Application for a non-material amendment following a grant of planning permission.

TECHNICAL DETAILS FOLLOWING PERMISSION IN PRINCIPLE APPLICATION (3/2023/0989) FOR RESIDENTIAL DEVELOPMENT COMPRISING 4 DWELLINGS.

CHANGE IN SIZE OF WINDOW TO NORTH WEST ELEVATION TO PLOTS 1, 2 AND 3.

Client Mr S Gill		
Project Proposed Development at Barrow Bridge House Club Street Barrow Clitheroe BB7 9AY		
Drawing Title Plot 1 Proposed Plans and Elevations		
Scale 1:50/100 @ A2	Date Nov 2024	Drawn LFR
READ DESIGN LTD		
161 - 02 c

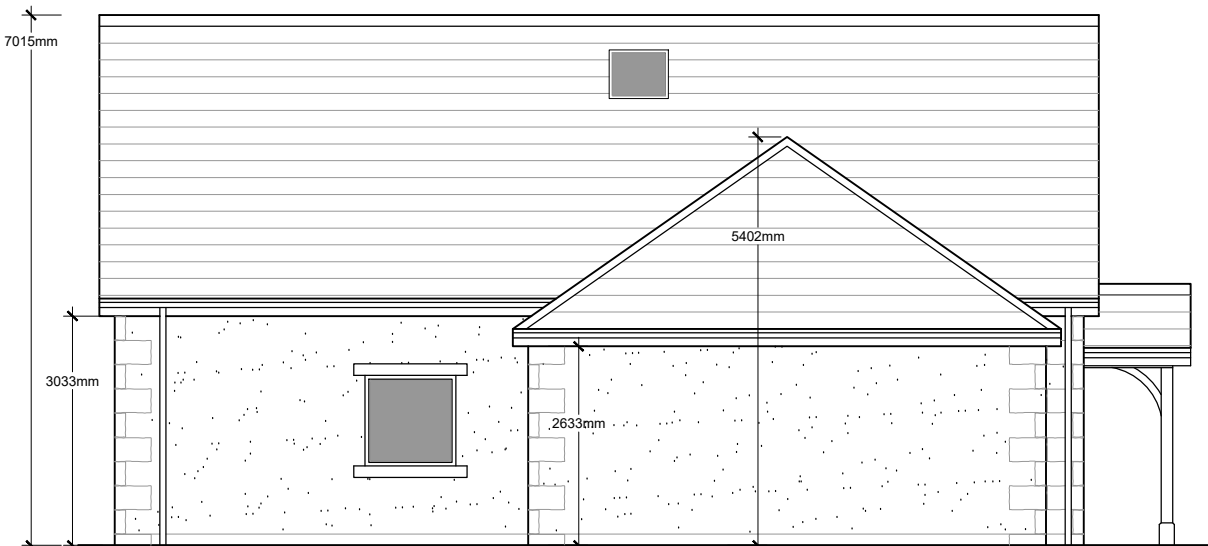
TO INCREASE WINDOW SIZE.
